Office of Water

7 January 2011

**MP10_0014 & CP10_0033 – Badgerys Creek Quarry project - Environmental
Assessment – Liverpool Local Government Area**

NSW Office of Water Comments

Indicative locations of the groundwater monitoring wells are provided on **Figure 11**, although it is noted that the final location of wells would be dependent on the outcomes of the drilling program.

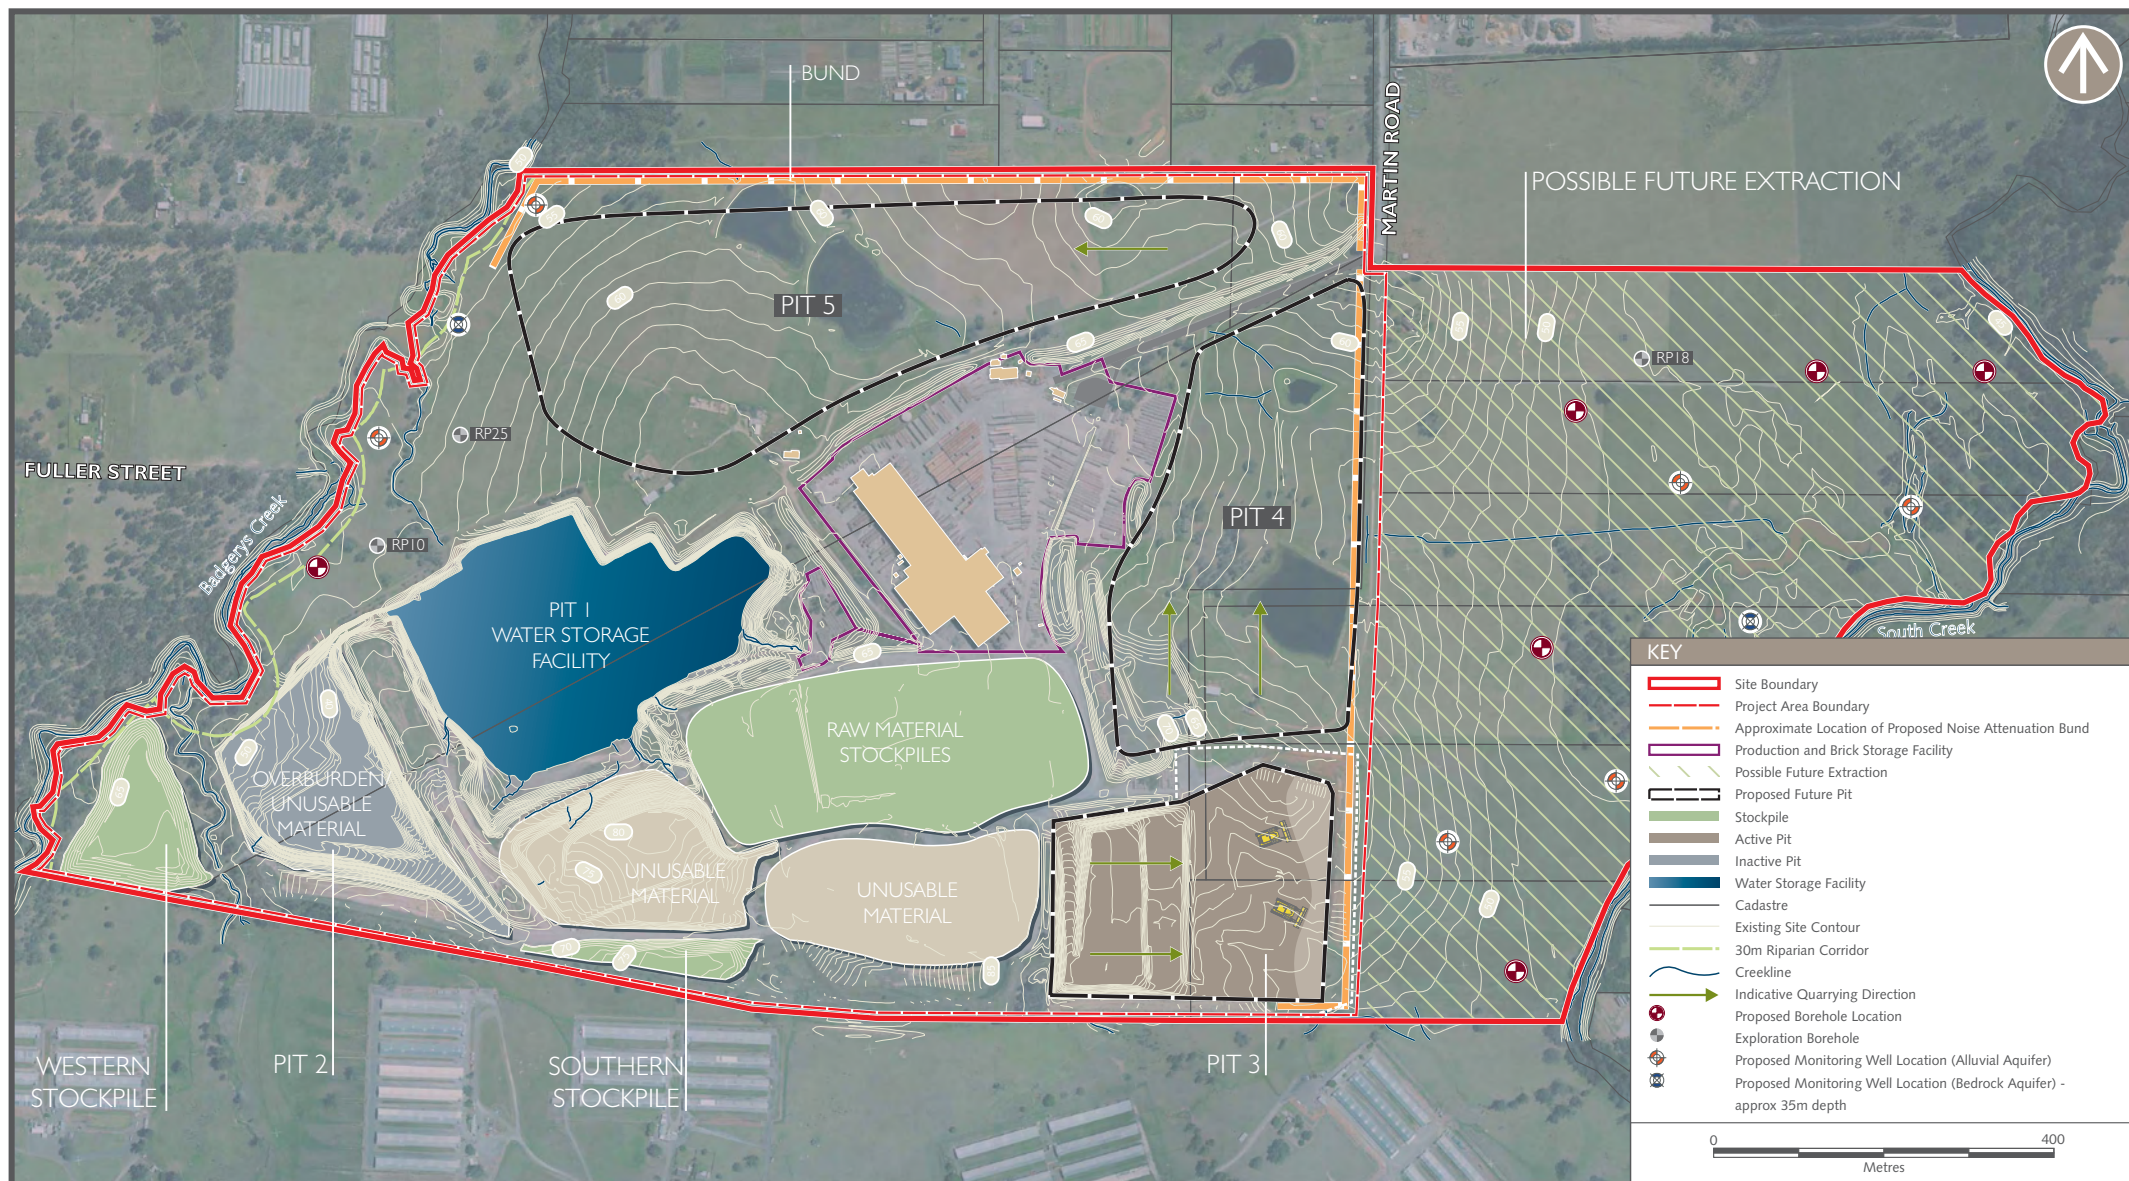
Section 11.6.1 of the EA indicates six groundwater monitoring wells would be installed within the alluvial sediments comprising four wells adjacent to South Creek and two wells adjacent to Badgerys Creek. The NOW recommends three wells are installed within the alluvial sediments adjacent to Badgerys Creek rather than only two wells.

Section 11.6.1 of the EA also indicates that two additional groundwater monitoring wells would be installed into the Bringelly Shale to a maximum depth of 35 metres. The NOW recommends three wells are installed into the Bringelly Shale – Bedrock Aquifer to a depth of 35 m rather than only two wells.

In addition to the above wells, the NOW recommends another three monitoring wells need to be installed as part of the groundwater monitoring program to a depth of 60 m.
